From: Simon Davis
Sent: 12 August 2019 15:17
To: [REDACTED]
Cc: [REDACTED]
Subject: FW: BR/125/19/PL 1-2 The Parade, Argyle Road

I write regarding this application. I have now made my assessment and must advise that we will be recommending this application for refusal. Our main reason for this is that the proposed additional storey will result in the building dominating the immediate streetscene and being out of character with what I consider to be the predominantly two storey form of buildings surrounding the site. I also have concerns regarding the impact of the side two storey extension on the windows on the neighbouring building to the south and the impact of the additional floor on the amenity of gardens to the east and also the same neighbour to the south. Finally, you should note that we would be looking for the flats to as a far as possible meet the 37m2 internal floor area as set out in the national space standards. I am not able to measure from the plans (please provide measurements) but consider that the new studio flats do not look like they will meet this requirement.

project title	1-2 Argyle Road, Bognor Regis	
drawing title	Proposed Ground Floor Plan

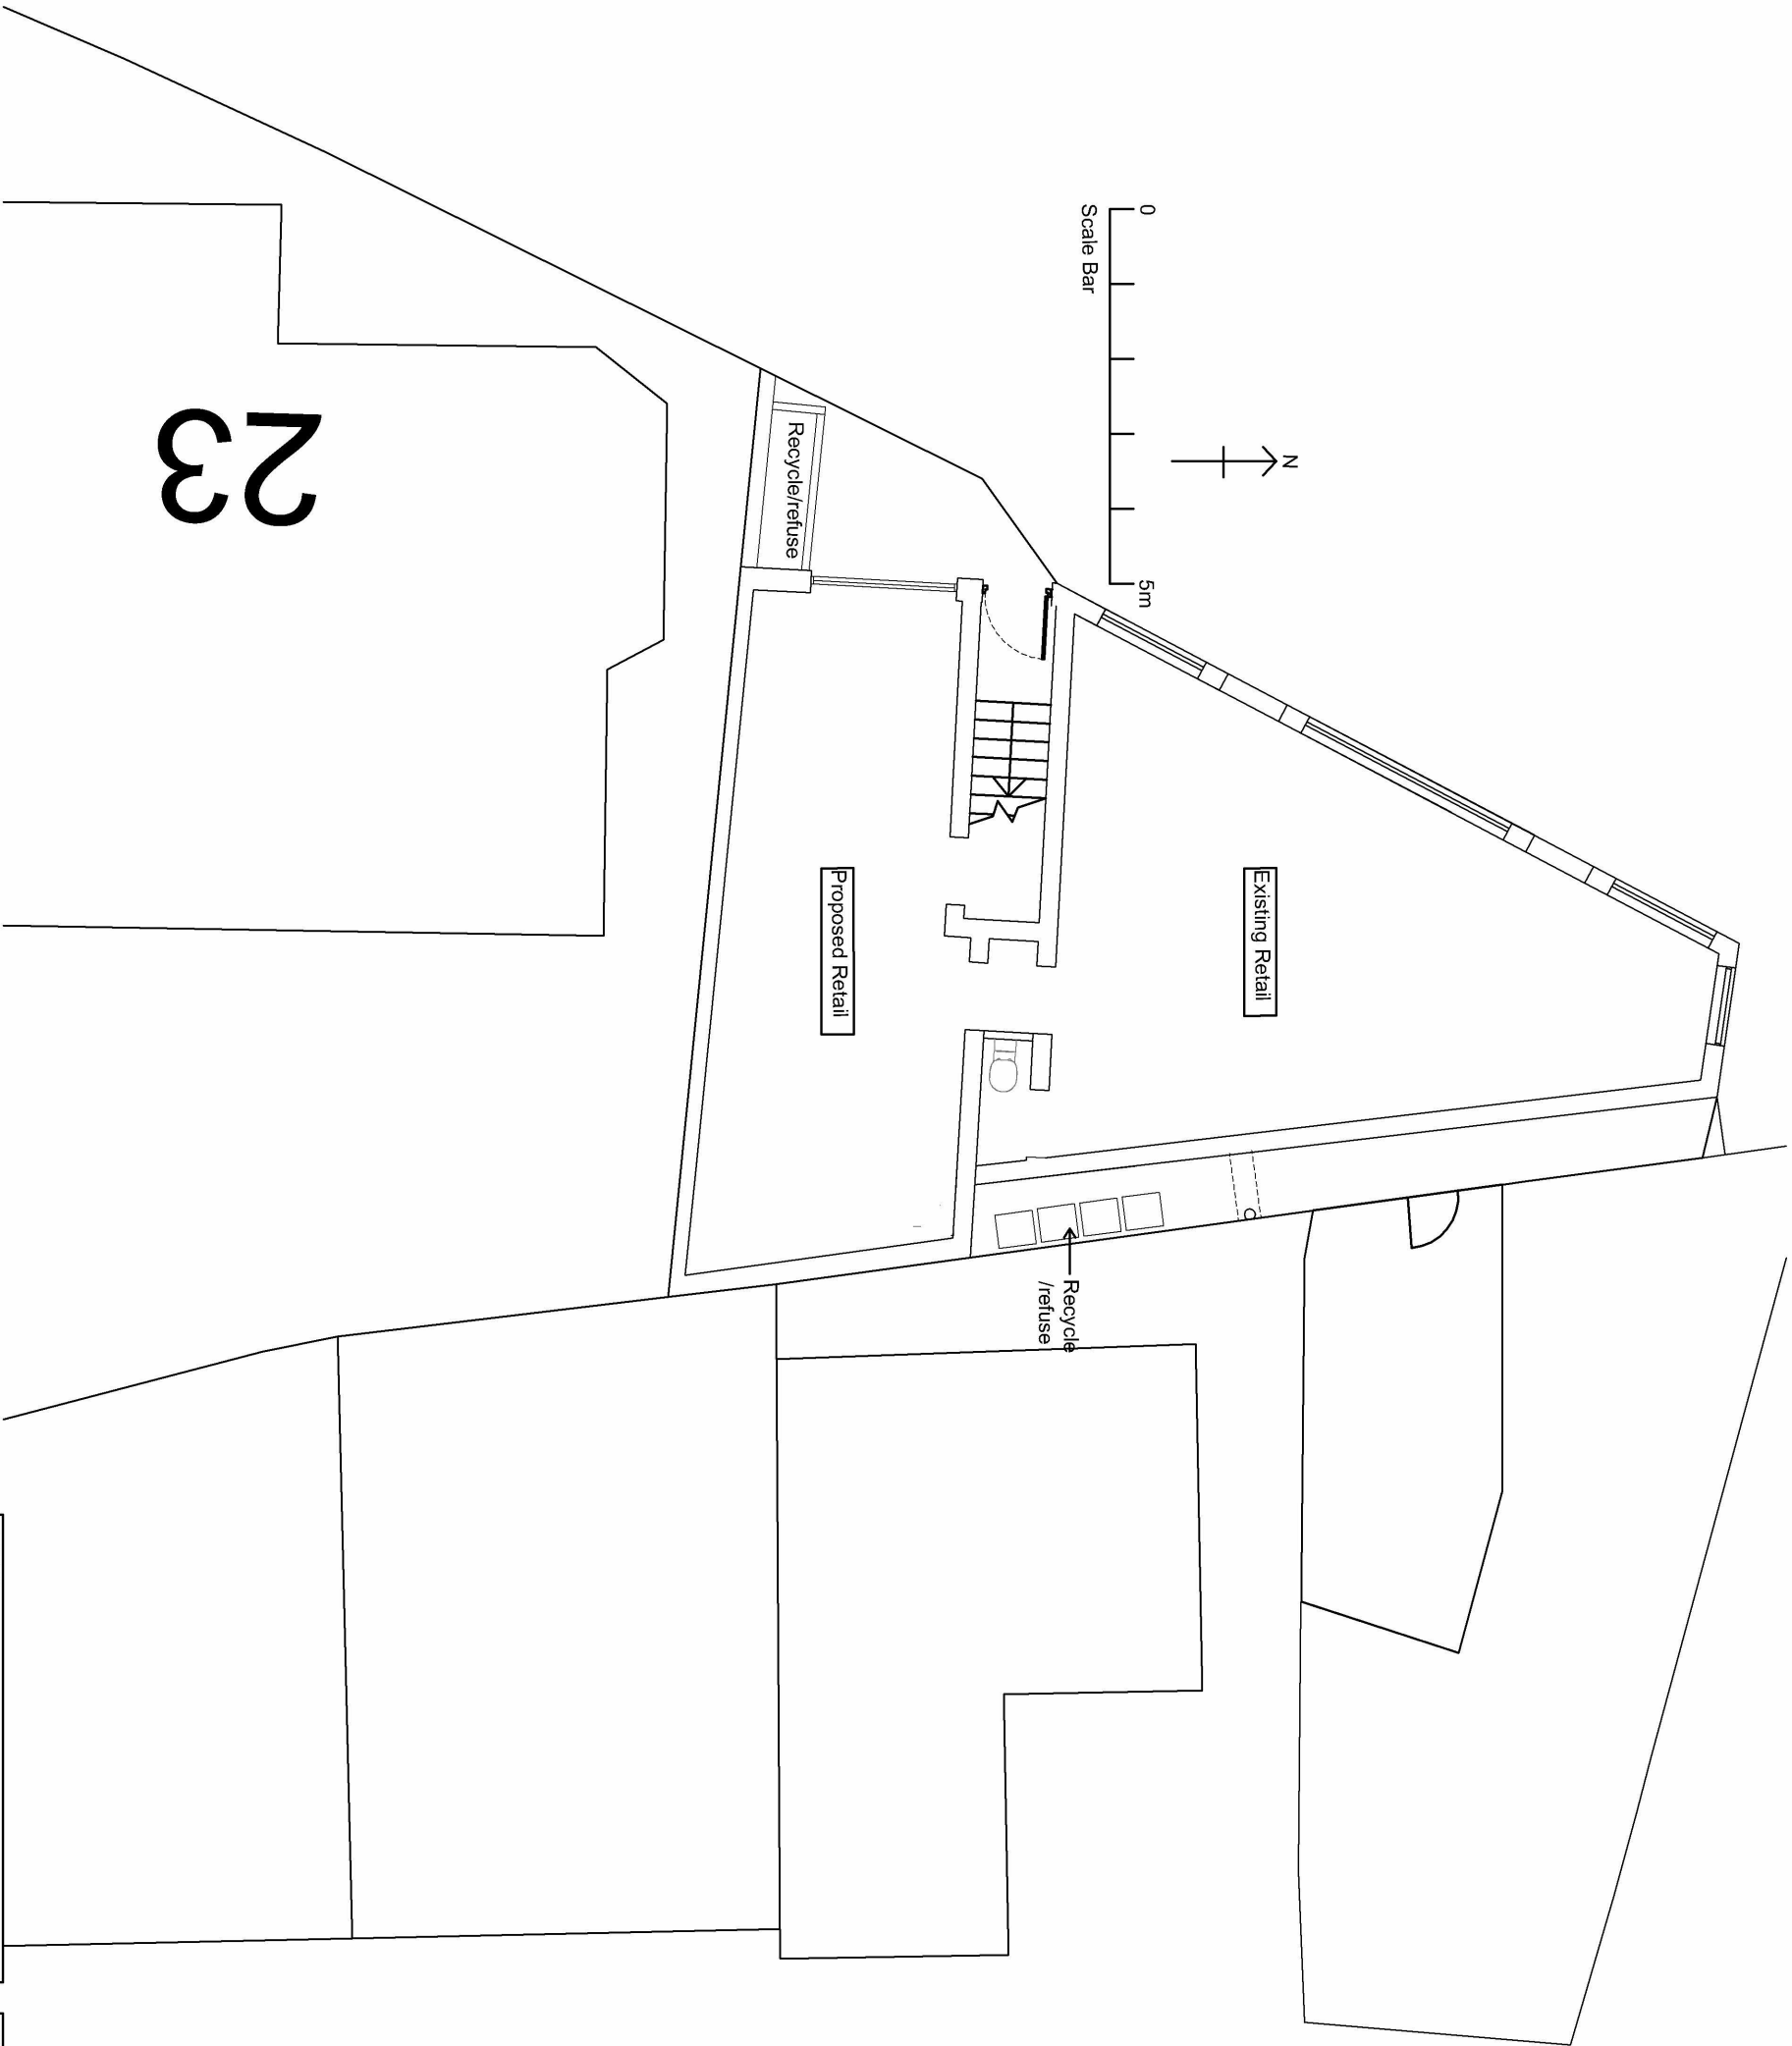
I have looked again at the side extension and consider that we may support the extension of this at ground floor but not above this due to the harm to the neighbours first floor flank windows and the amenity of their garden. However, I also note that the proposed side extension results in the loss of 2 off-street parking spaces and we may resist this particularly as there does not seem to be any space for cycle parking to compensate for this loss.
